# SSD 7033: Response to Submissions

Site 53, 2 Figtree Drive, Sydney Olympic Park

May 2016

STREET LEVEL ENTRANCES

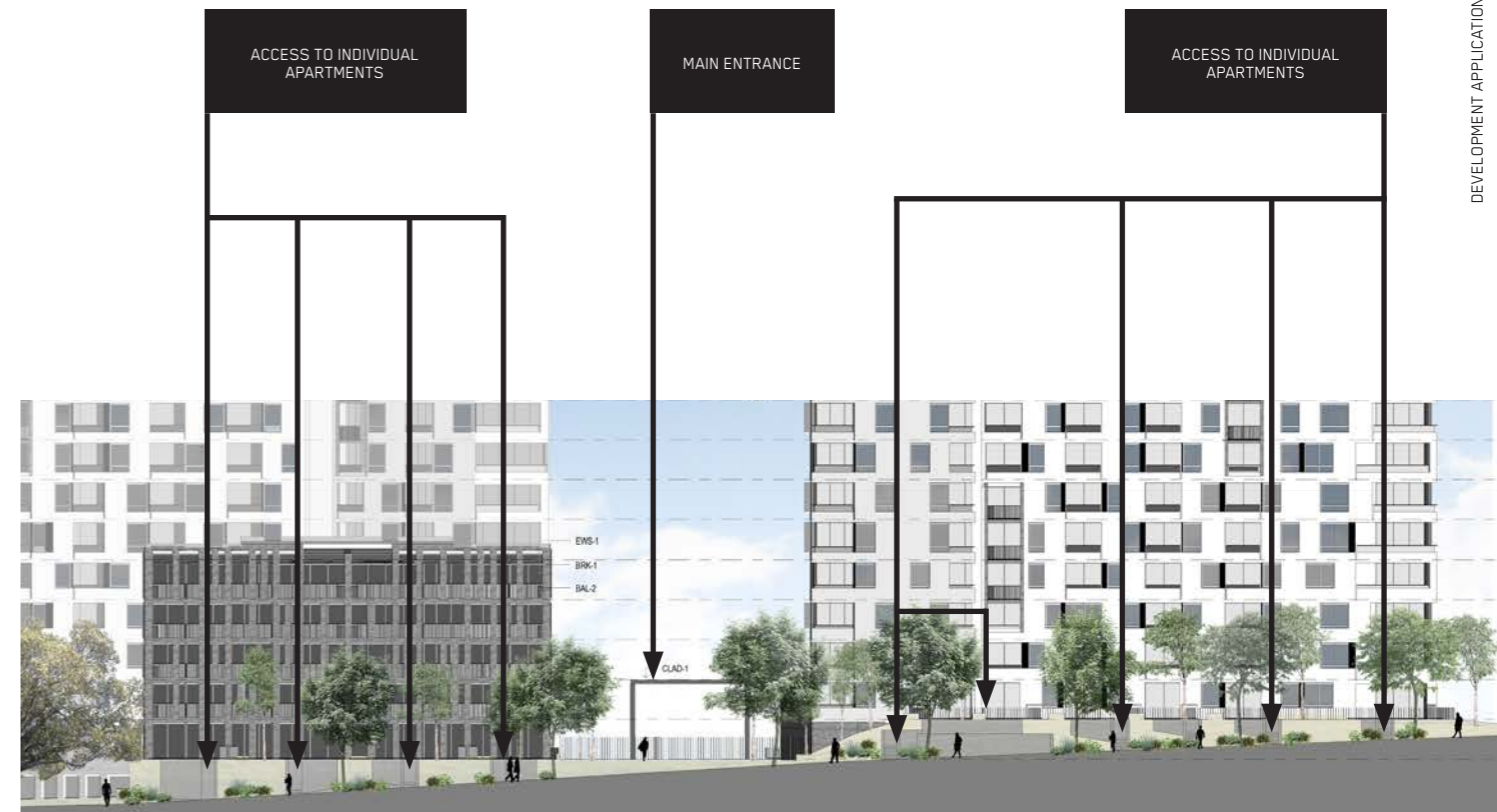
- *indicating on the architectural plans the location of the street level entrances to individual apartments fronting onto Figtree Drive and new street;*

Street level entrances have been provided to ground floor apartments wherever possible (refer Figure 2). Specifically, street level entrances are provided for all ground floor apartments fronting Figtree Drive and two of the three ground floor apartments fronting New Street. Due to significant level differences along New Street, of up to 3m between the footpath and ground floor units, it is impracticable to provide steps to every apartment.

VIEW FROM SOUTHERN SIDE OF FIGTREE DRIVE TOWARDS BICENTENNIAL MARKER

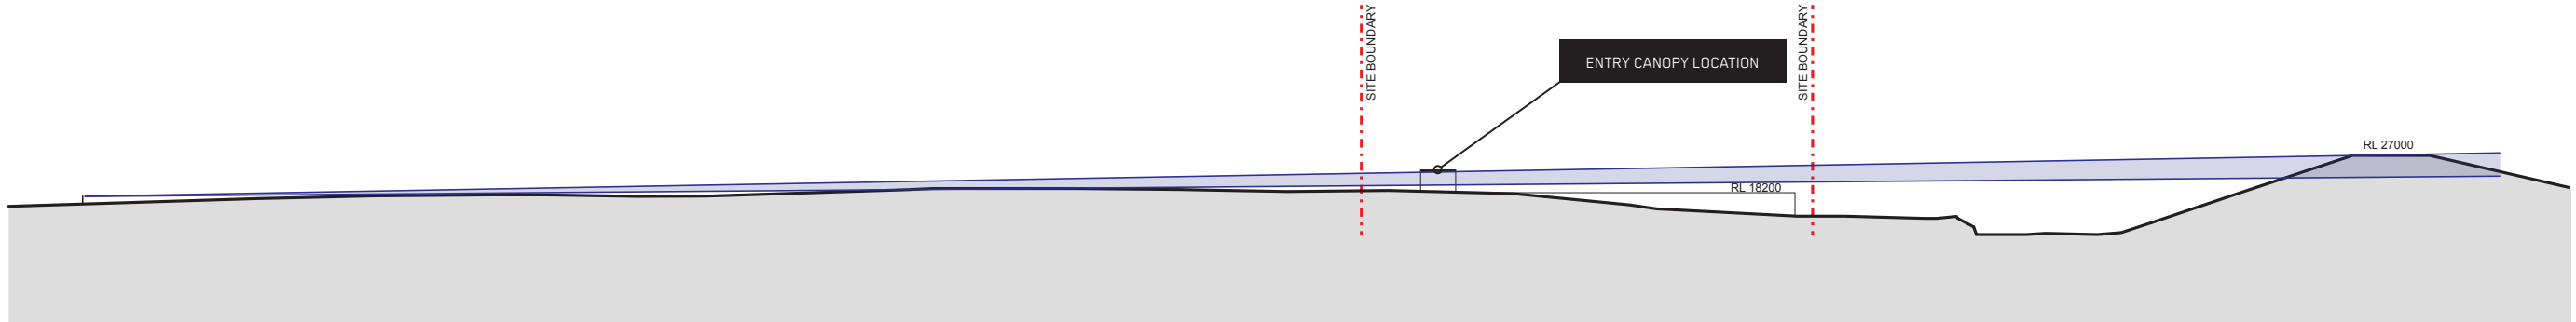
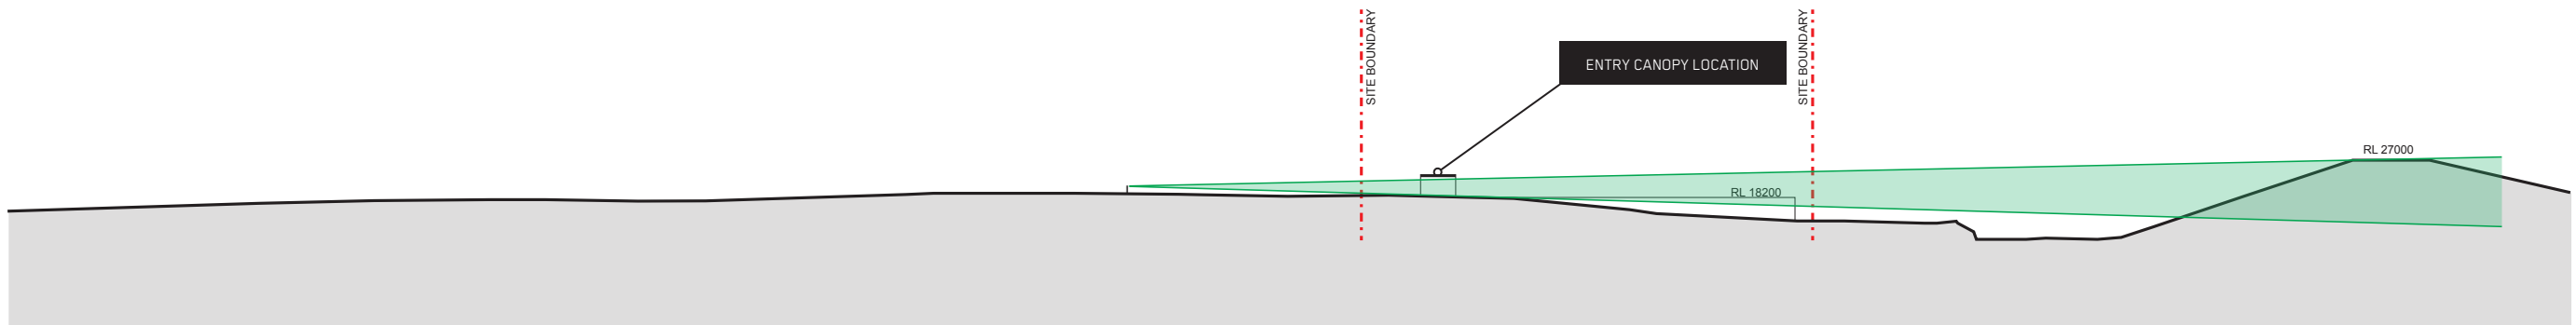
**Building height:** *It is noted that the maximum building heights have gradually increased from 10 to 16 stories through the design development process. The Authority's Design Review Panel (DRP) has generally supported these changes but was concerned that the building articulation shown in earlier sketches has somehow disappeared and that the tallest block now appears quite monolithic. Some of the original design features such as the castellated parapet at the top of the building (which helped to reduce the visual impact of the extra height) has now been infilled. The EIS has not responded to this issue and it is recommended that the original design of the parapet be reinstated as requested by the DRP.*

As shown in the Design Report prepared by BVN and included at **Appendix B**, an iteration of the design scheme presented to the SOPA Design Review Panel introduced a castellated parapet line as a way to break down the scale of the built form (refer Figure 3).

The SSD application scheme facade is a development of this idea of reducing the scale of the built form with brick framed 'pop-out' elements (refer Figure 4). These framed brick elements articulate the façade and introduce variation in the materiality.

# BUILT FORM ARTICULATION

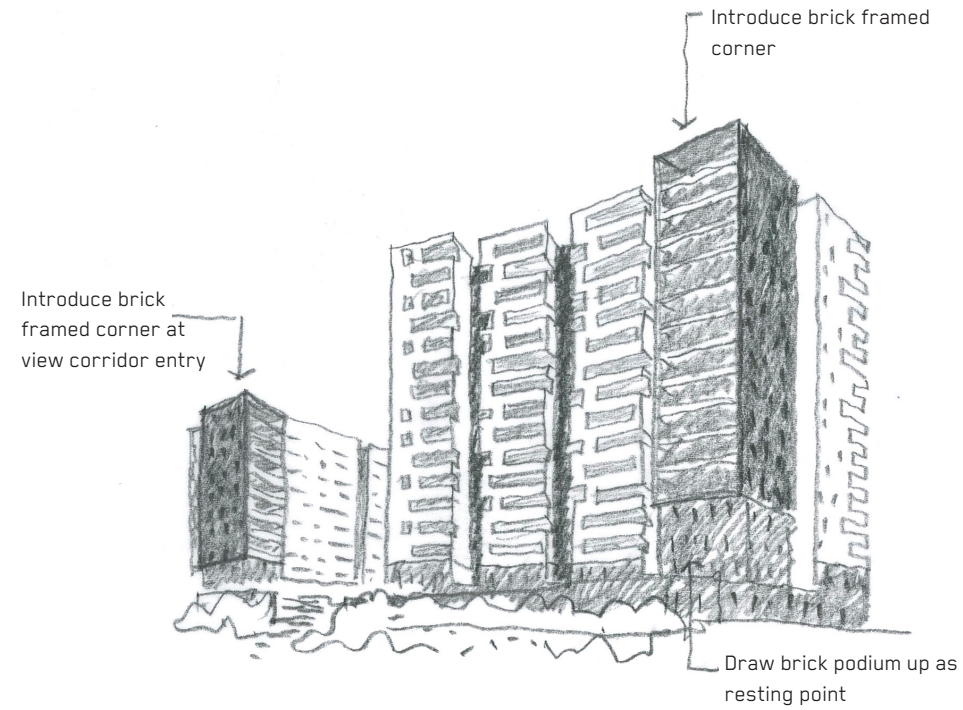
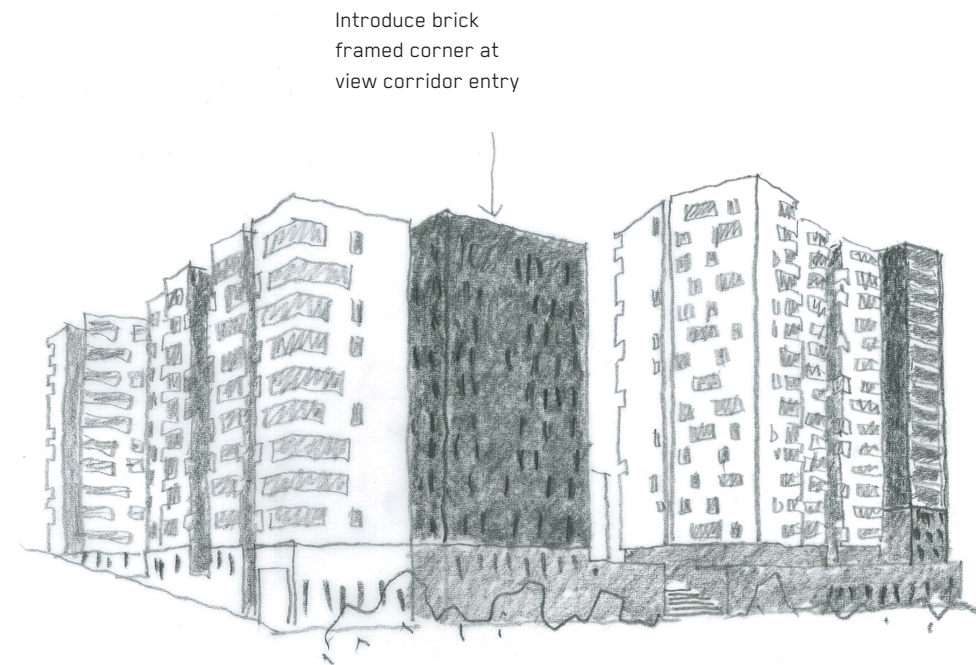
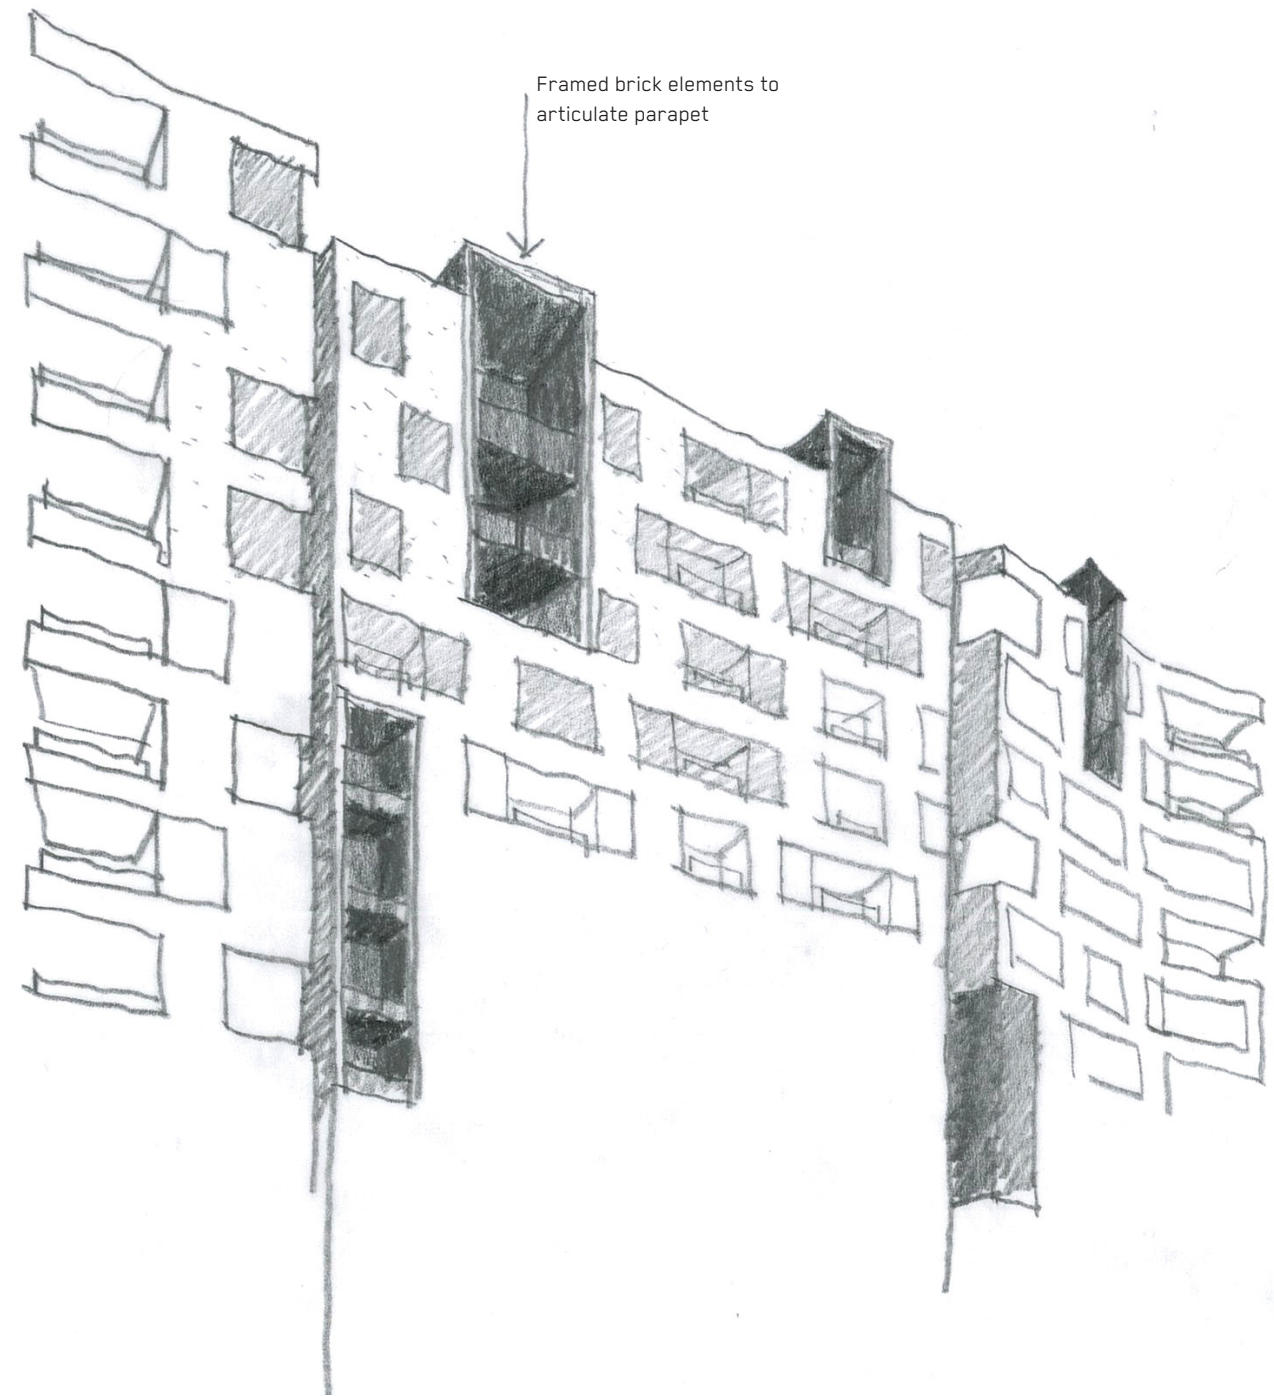
**Face brickwork:** The use of face brickwork in this project is strongly supported. It will help to add warmth and texture to the urban character of Sydney Olympic Park. One concern is that earlier sketches showed the feature corner with a strongly expressed window pattern which has disappeared from the DA scheme and been replaced with full width balconies on the most visible (SE facing) frontage. It is recommended that the facebrick character of the SE frontage be reinstated to match the lower levels (1 to 3) of this tower element.

Face brickwork is heavily featured throughout the proposed development. The face brick character of the south-east frontage is retained through the inclusion of two brick framed corner elements on the south-east and south-west buildings, which relate to the podium below (refer Figure 5).

The previously proposed window pattern on the south-east corner of the fifteen-storey tower has been replaced with full width balconies to south facing apartments in order to provide adequate residential amenity, in particular these apartments will have greater access to district and city views and natural daylight despite their southerly orientation.
